**RE: Durango Subdivision, Units 3 - 5  
Tr H, Durango Unit 1 & Tr A Durango Unit 3A  
Drainage Report Stamp Date: 3/5/15  
Unit 3 Grading Plan Stamp Date: 8/12/15 (Approved for Plat, 8/18/15)  
Unit 3A Grading Plan Stamp Date: 1/18/19  
Unit 4 Grading Plan Stamp Date: 8/12/15 (Approved for Grading, 8/18/15)  
Unit 5 Grading Plan Stamp Date: 1/18/19  
Hydrology File: C09D012**

Based on the submittal received on 1/18/19 the above-referenced Grading Plans cannot be approved until the following are corrected:

WEST DRAINAGE WALL PLAN DETAIL  
NOT TO SCALE

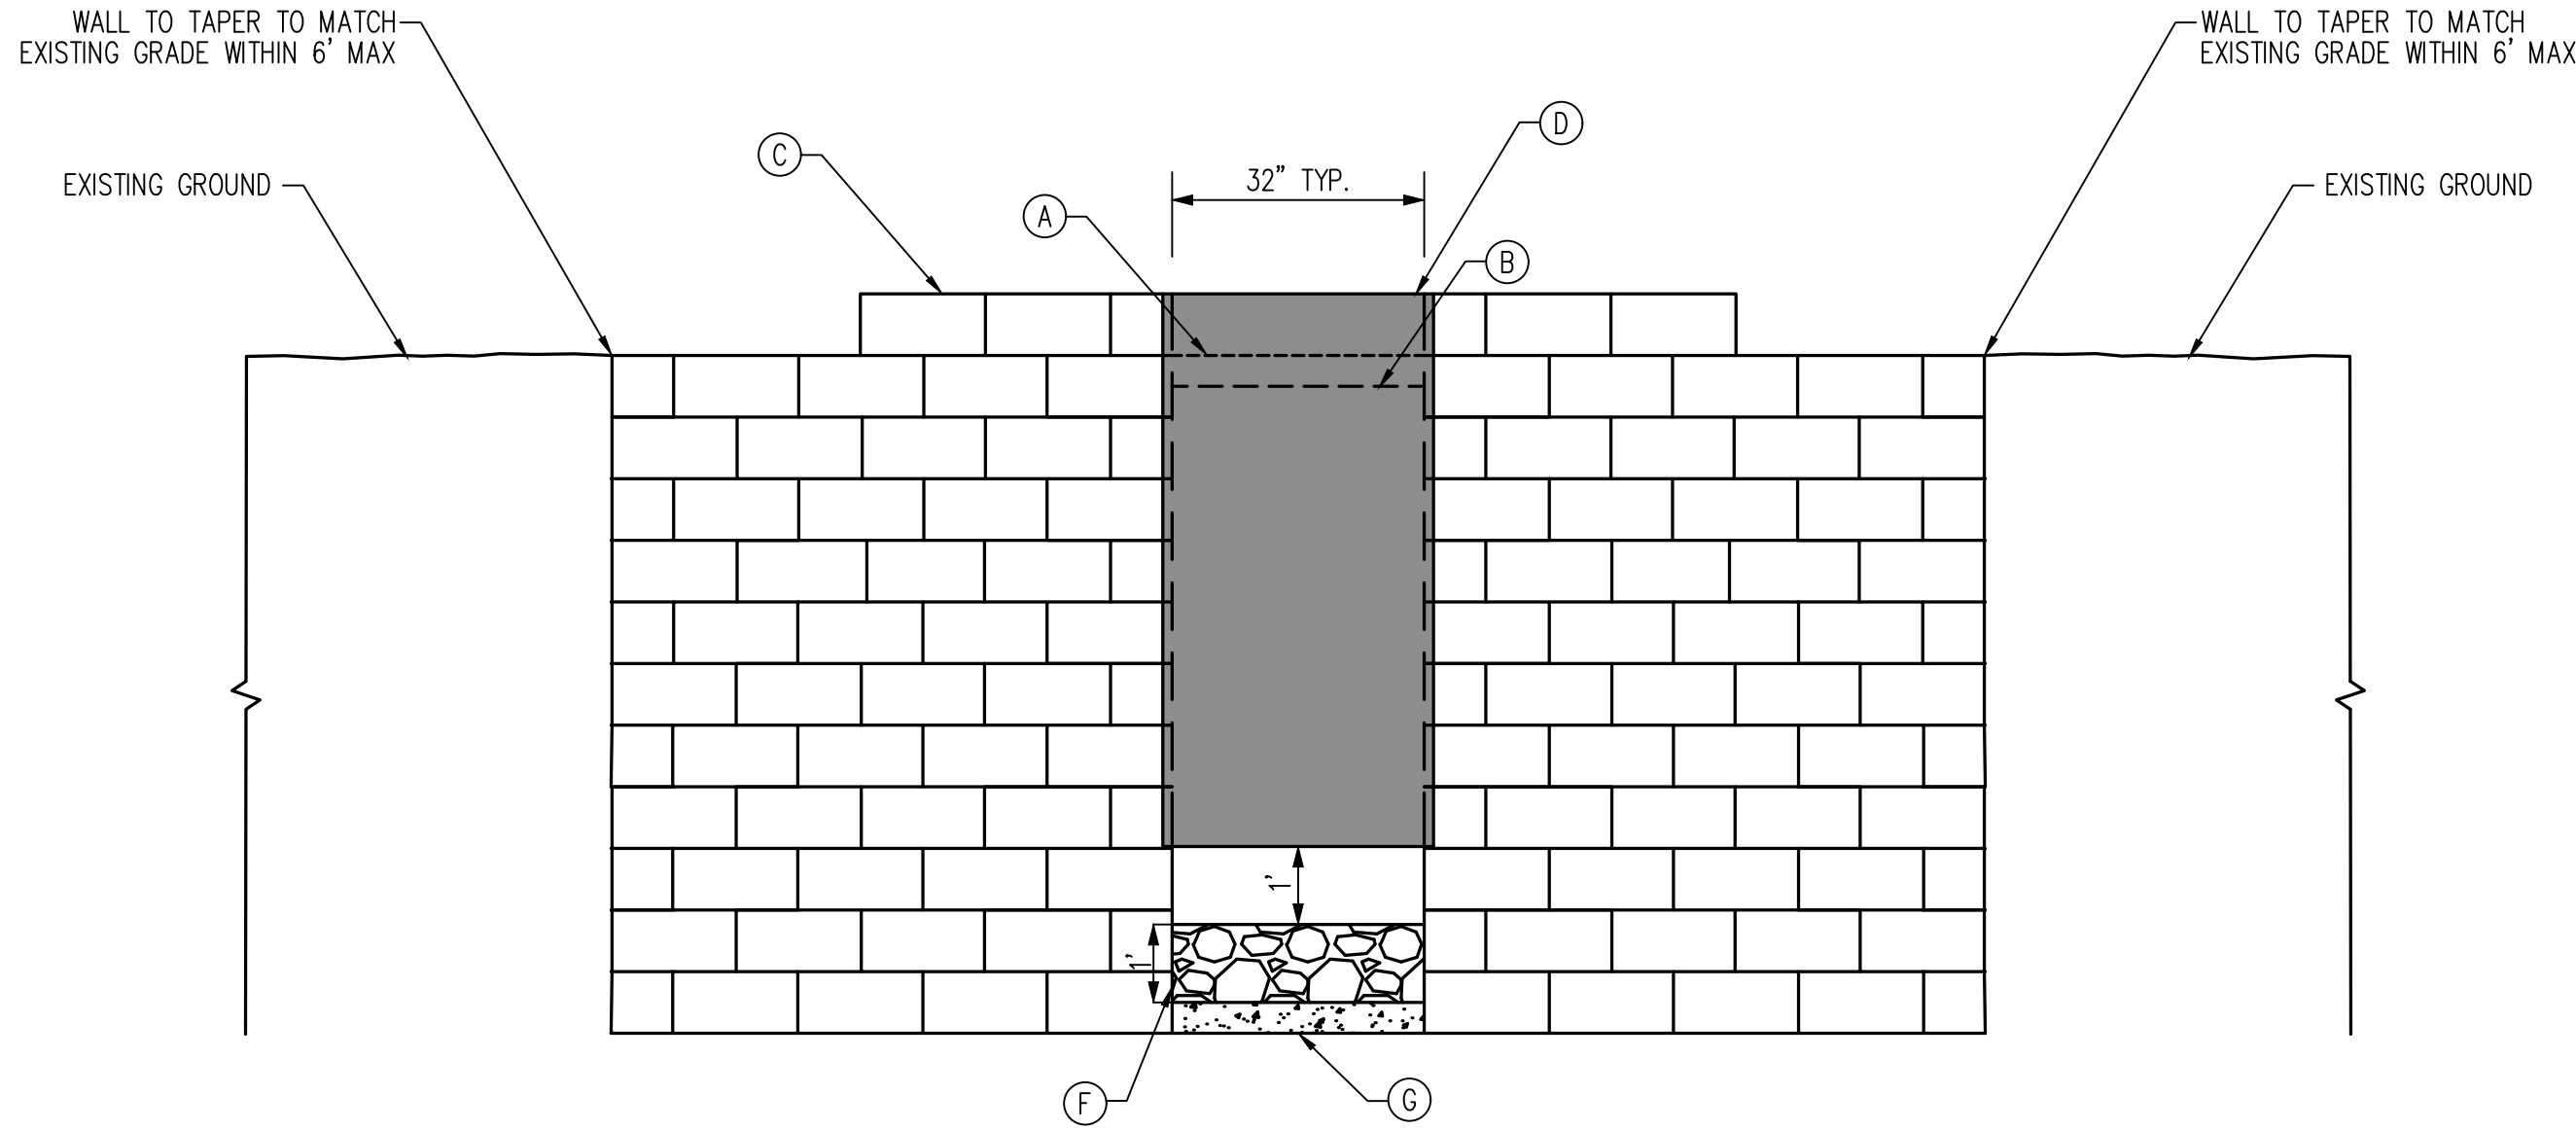
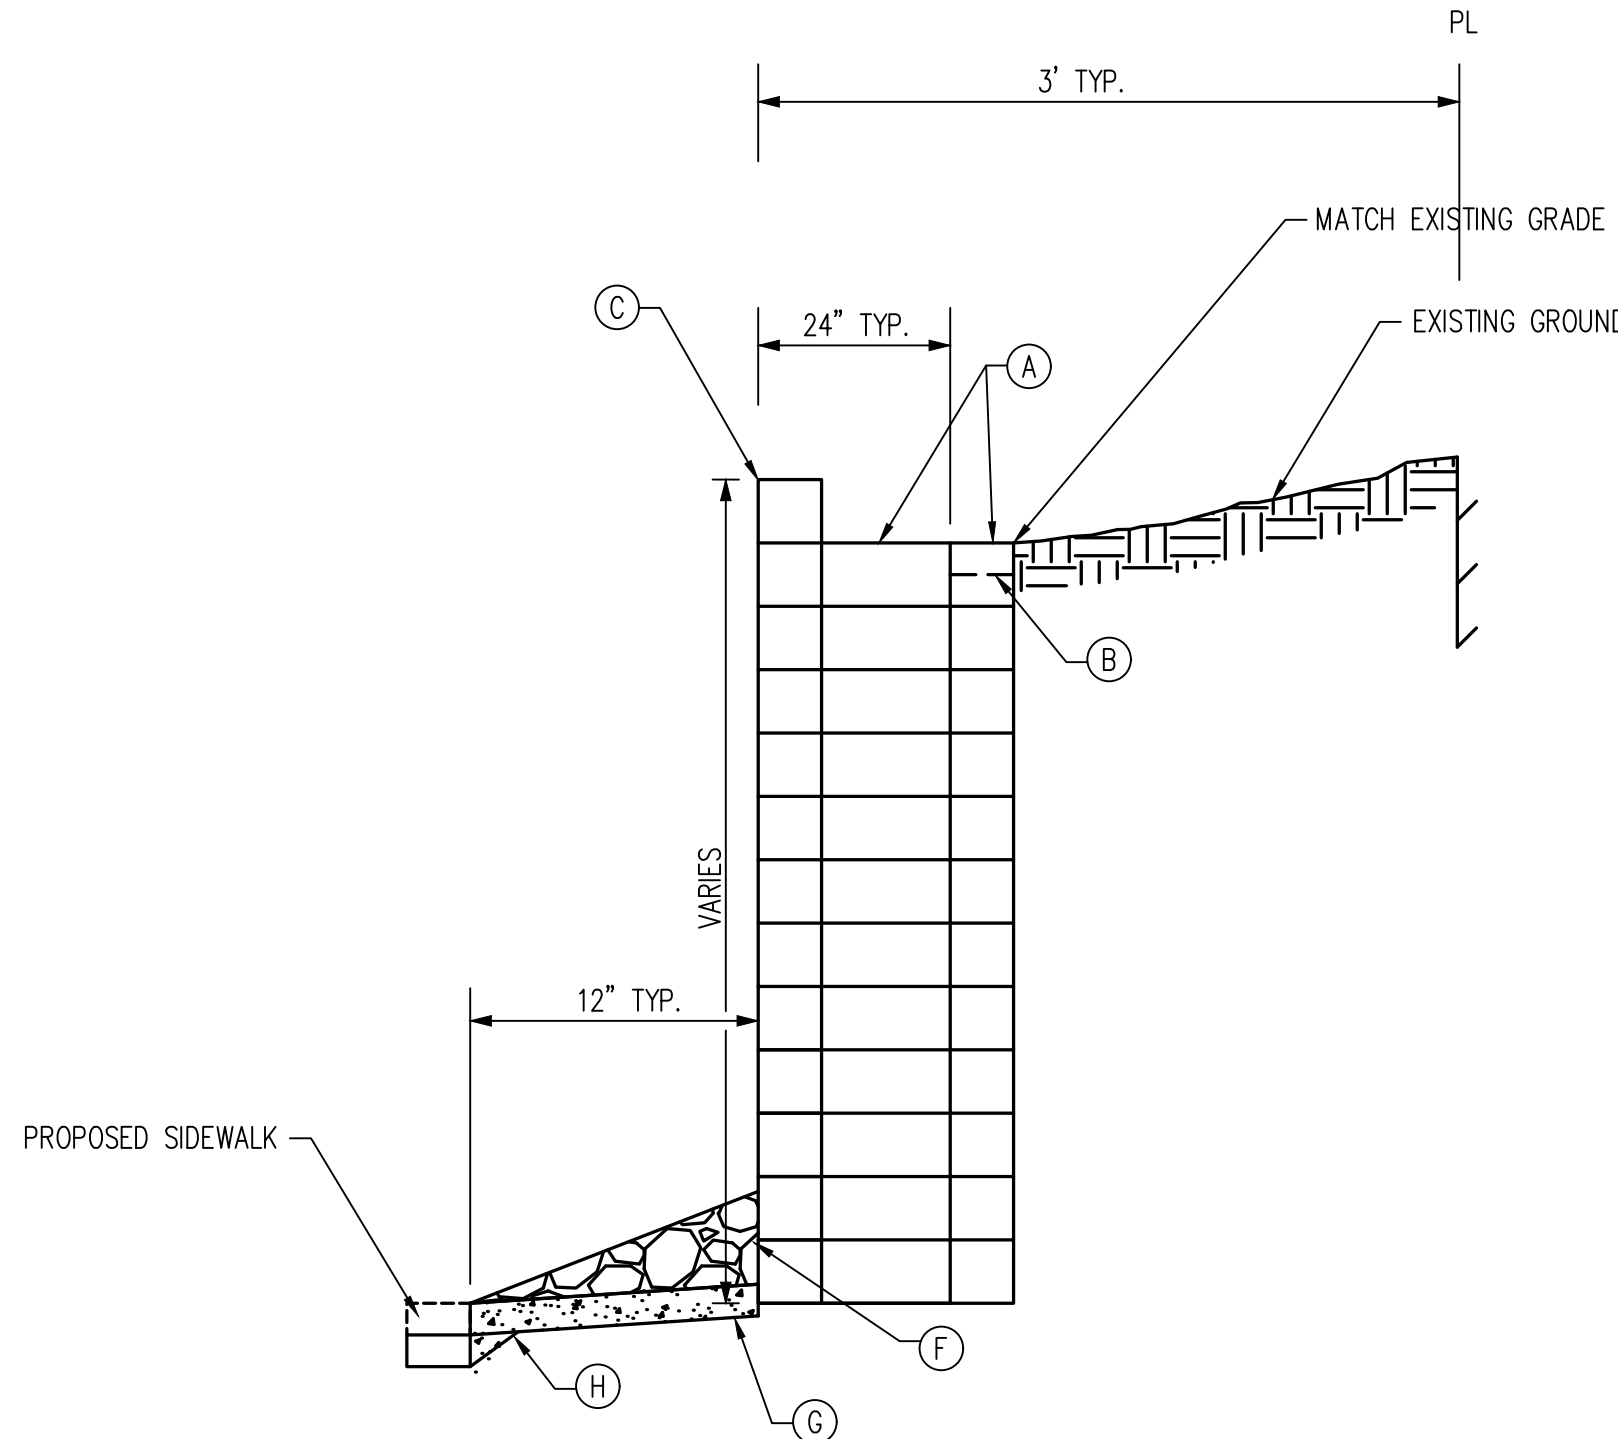
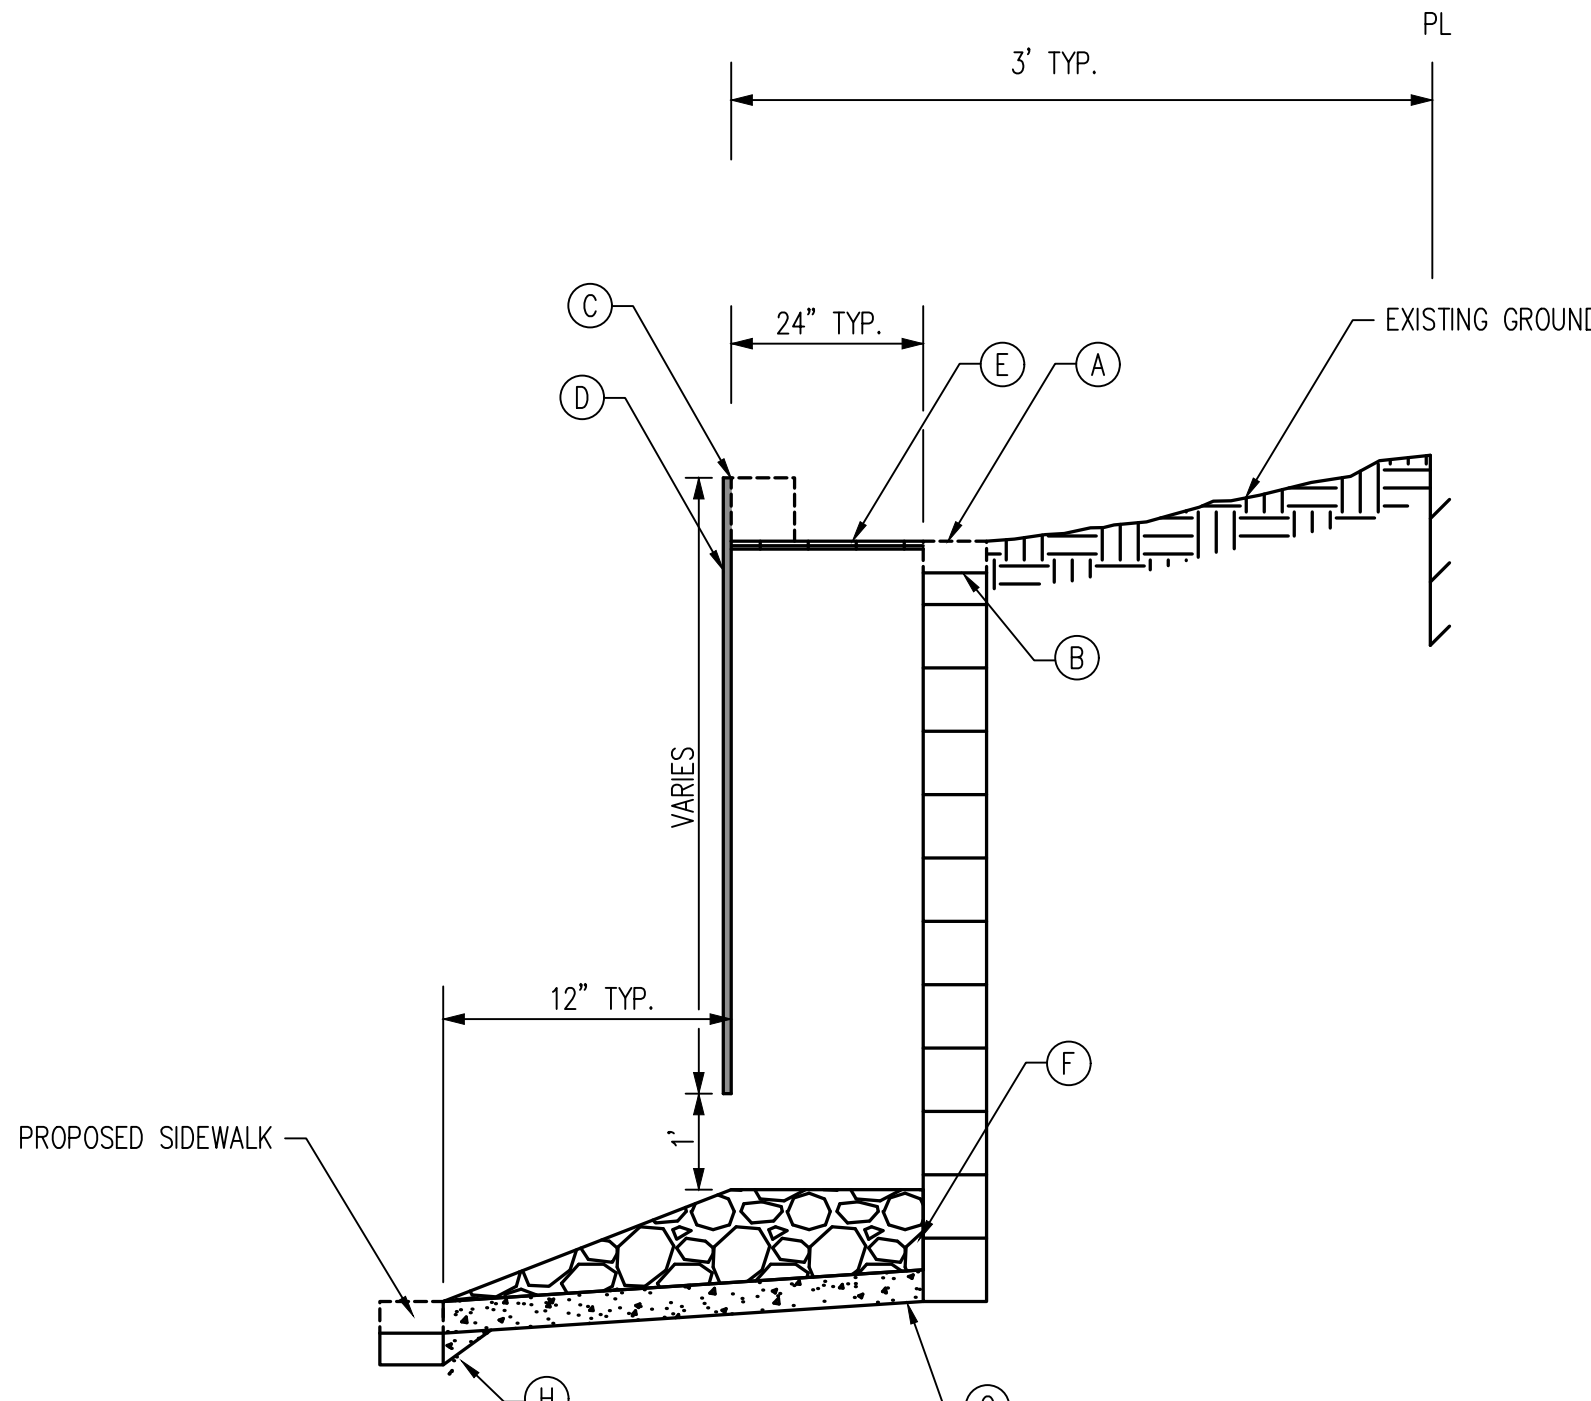
7. Along all external boundaries, provide sections of the proposed retaining walls and show the property line, existing and proposed grades on the section views. Include diversion channels and berms if present. In accordance with DPM Ch.22, section 5 part B, grading and wall construction near the property line may not endanger adjacent property or constrain its use. Ensure that the retaining walls (including footers) do not encroach on neighboring property or public ROW.

8. Special care must be taken while grading adjacent to the Open Space. Identify all concentrated flow paths entering this subdivision and provide grade control and controlled flowpaths into the subdivision. Provide details showing how this will be accomplished, similar to what was required for Del Webb 3&4. Ensure all slopes are stabilized to prevent headcutting and erosion back into the Open Space.
